RE: Roslyn Ridge West Ph 3 Application (LPF-26-00002)

Parcel #'s: 964138

Kittitas County Community Development Services received a Final Long Plat application for a the Roslyn Ridge West PUD. The subject parcels are located off State Route 903 approximately 3.6 miles northwest of the intersection of State Highway 903 and Bull Frog Road, northwest of Roslyn, WA in Kittitas County. The application was received on May 6, 2026. Please be advised that the following actions will need to be completed prior to the recording of final mylars.

LEGAL DESCRIPTION PER :

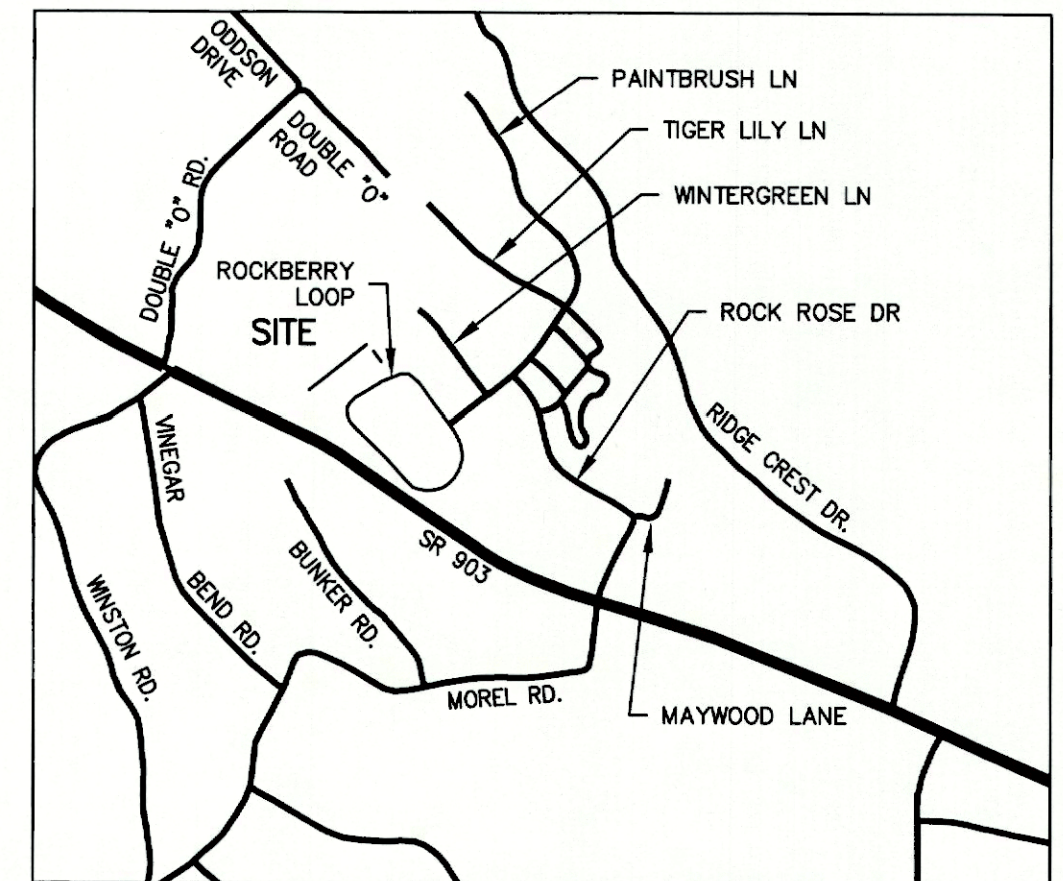
SURVEY	1. The Plat Dedication does not address Road dedication. The dedication could be revised or a note including granting the road to an HOA or evenly divided between owners of the Plat. 2. Existing Legal Description absent from Sheet 2. 3. Please set and show property corners on the face of the plat. 4. If the untied found corner located on the South line of the subject property was utilized for survey control, please include bearing and distance ties to this corner. 5. Please label and identify the detail window for the access easement (Detail B?) 6. The 'Tick marks' or 'crows feet' on the west edge of Double O Ranch Road appear to be incorrect. I believe these should be on the West side of road. 7. Please identify total width of Double O Ranch Road. 8. Existing Lot 10, should include reference to the Plat of Record (AFN or Plat 14-140) 9. The label for Oddson Drive has been trimmed off on Sheet 4. 10. To identify access to nearest public right of way, please label the following roads, (width, ownership and surfacing not required): Rockberry Loop Paintbrush Lane Rockrose Drive Rather than drawing in Rockrose drive, a label with the note "0.3 Miles to SR903" would be suitable. (JT)

ROSLYN RIDGE P.U.D. PHASE 3 PLAT
 A PORTION OF THE NW 1/4 OF SECTION 12,
 TOWNSHIP 20 NORTH, RANGE 14 EAST, W.M., KITTITAS COUNTY, STATE OF WASHINGTON

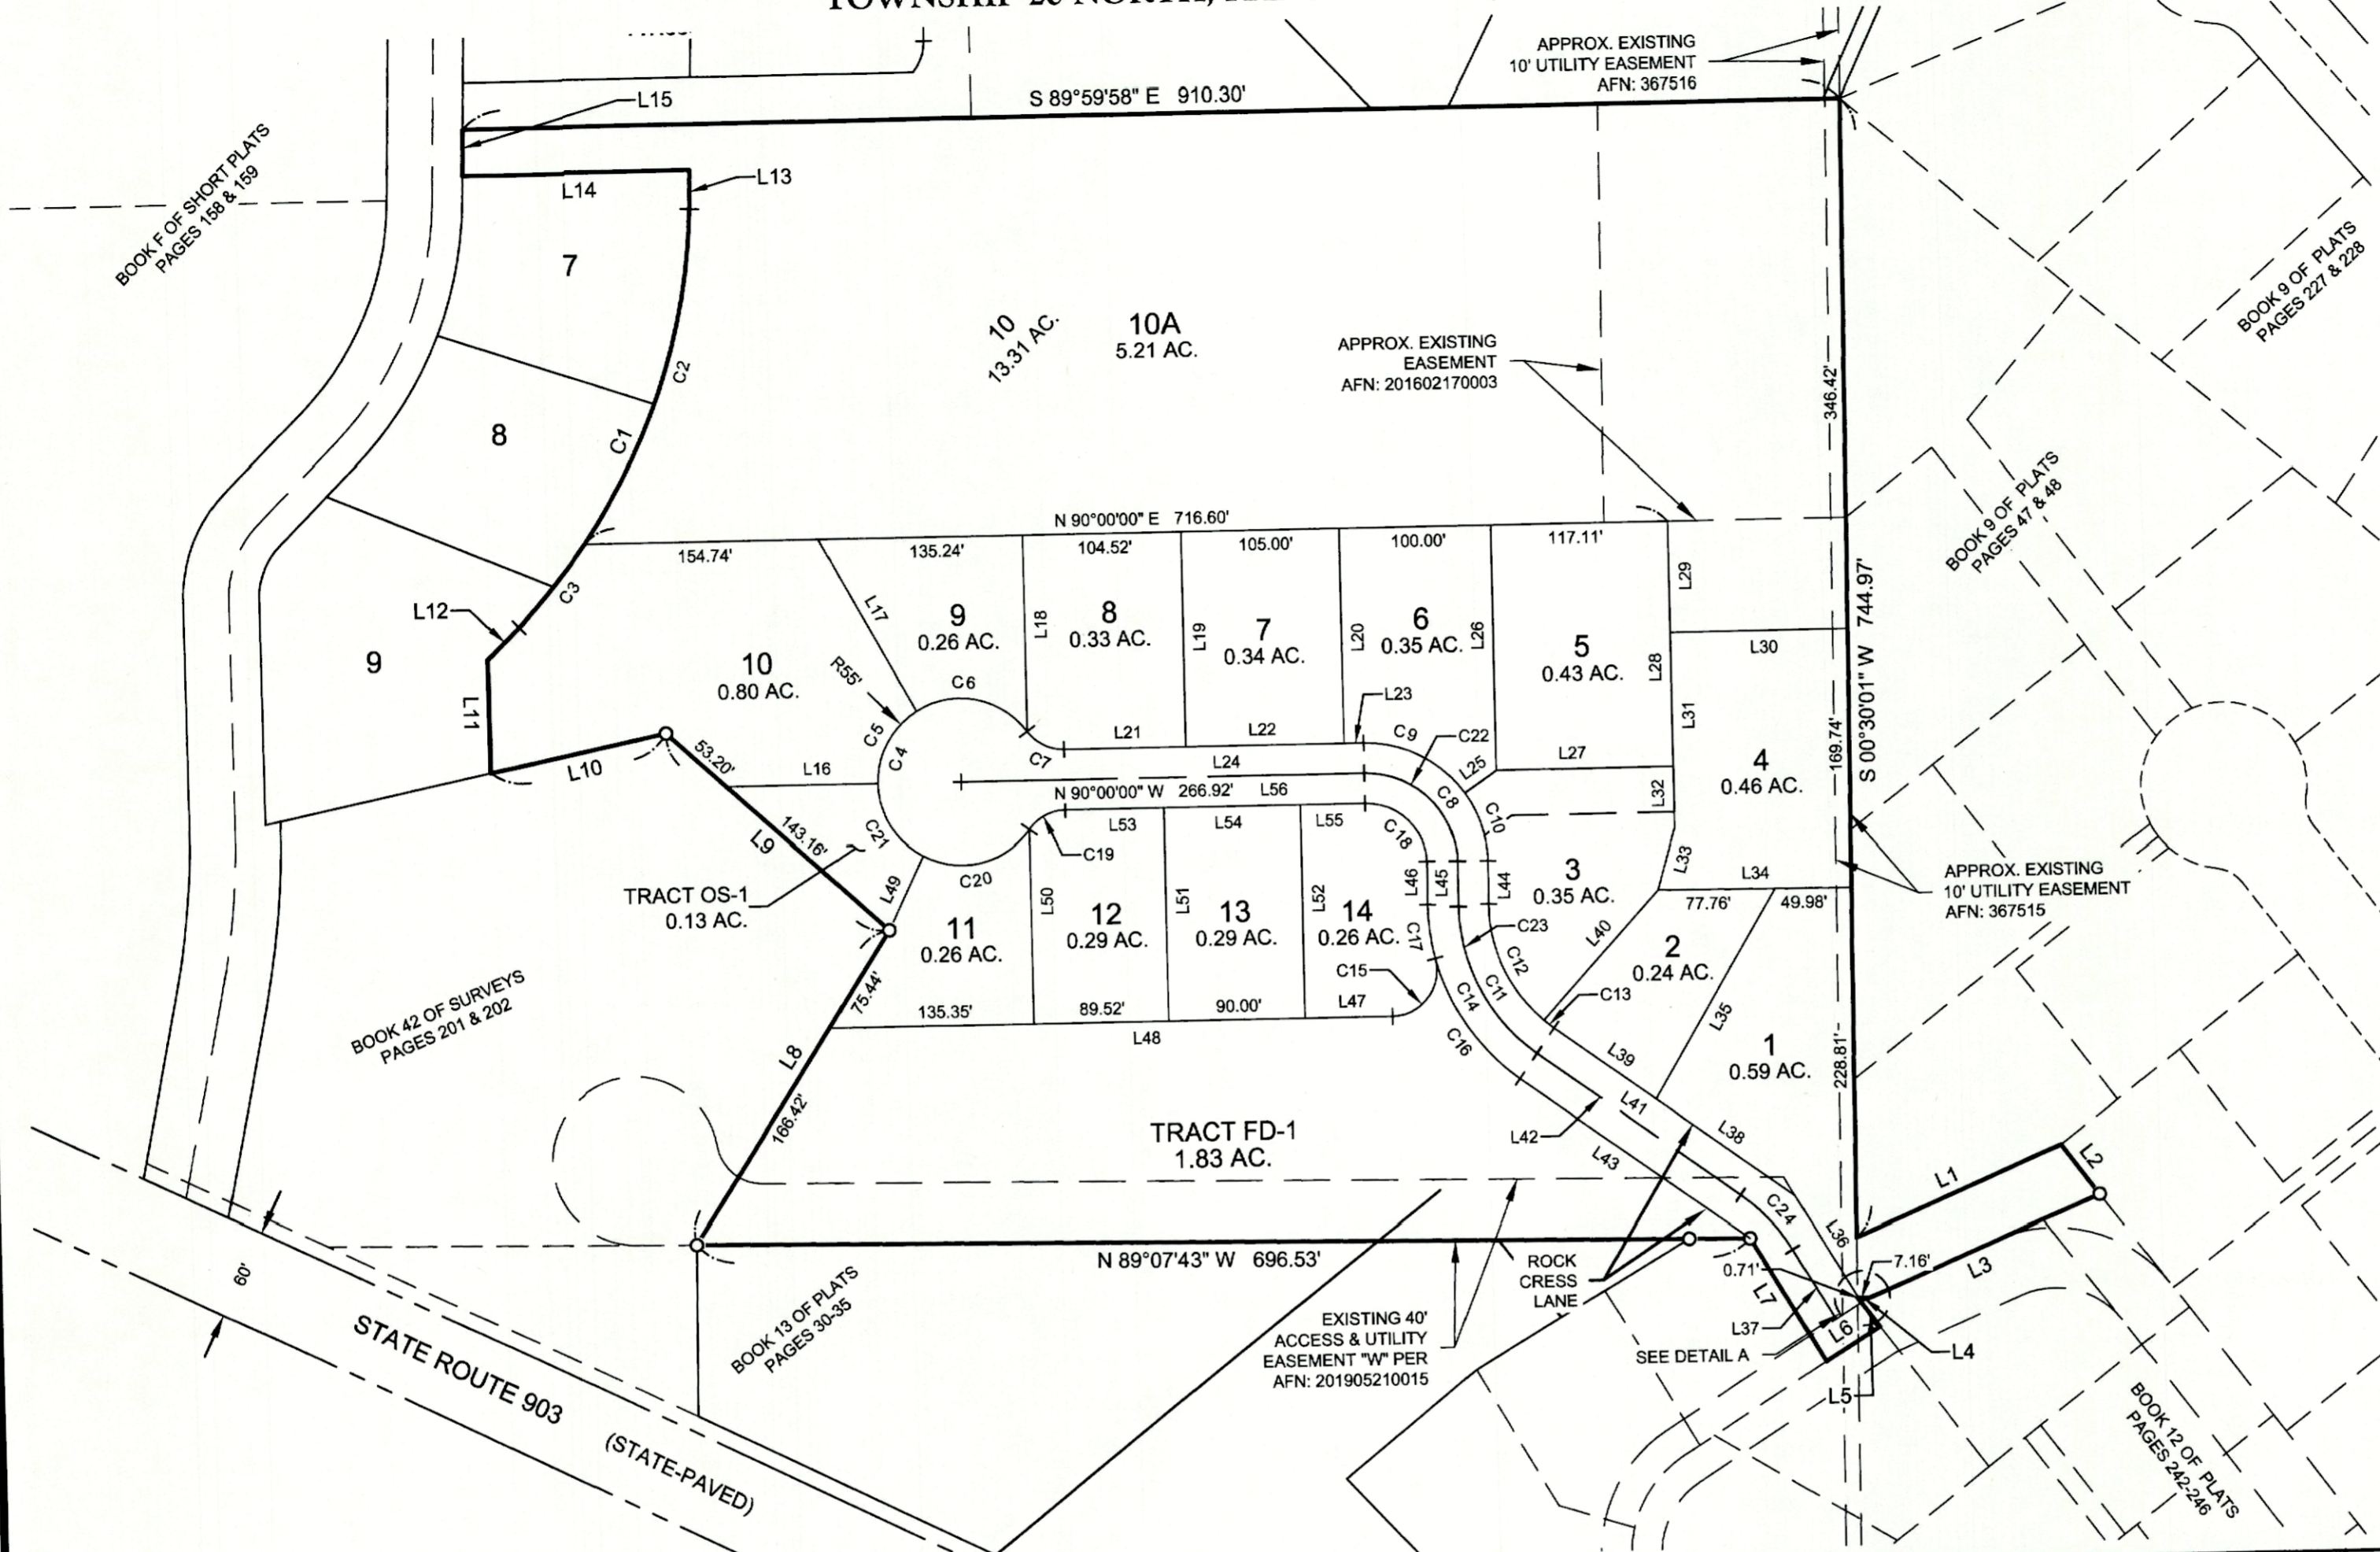
L24 & L56 have the same direction and distance listed in the tables on sheet 5. Should these distances be the same or do they reference different lines on sheet 3 of the plat?
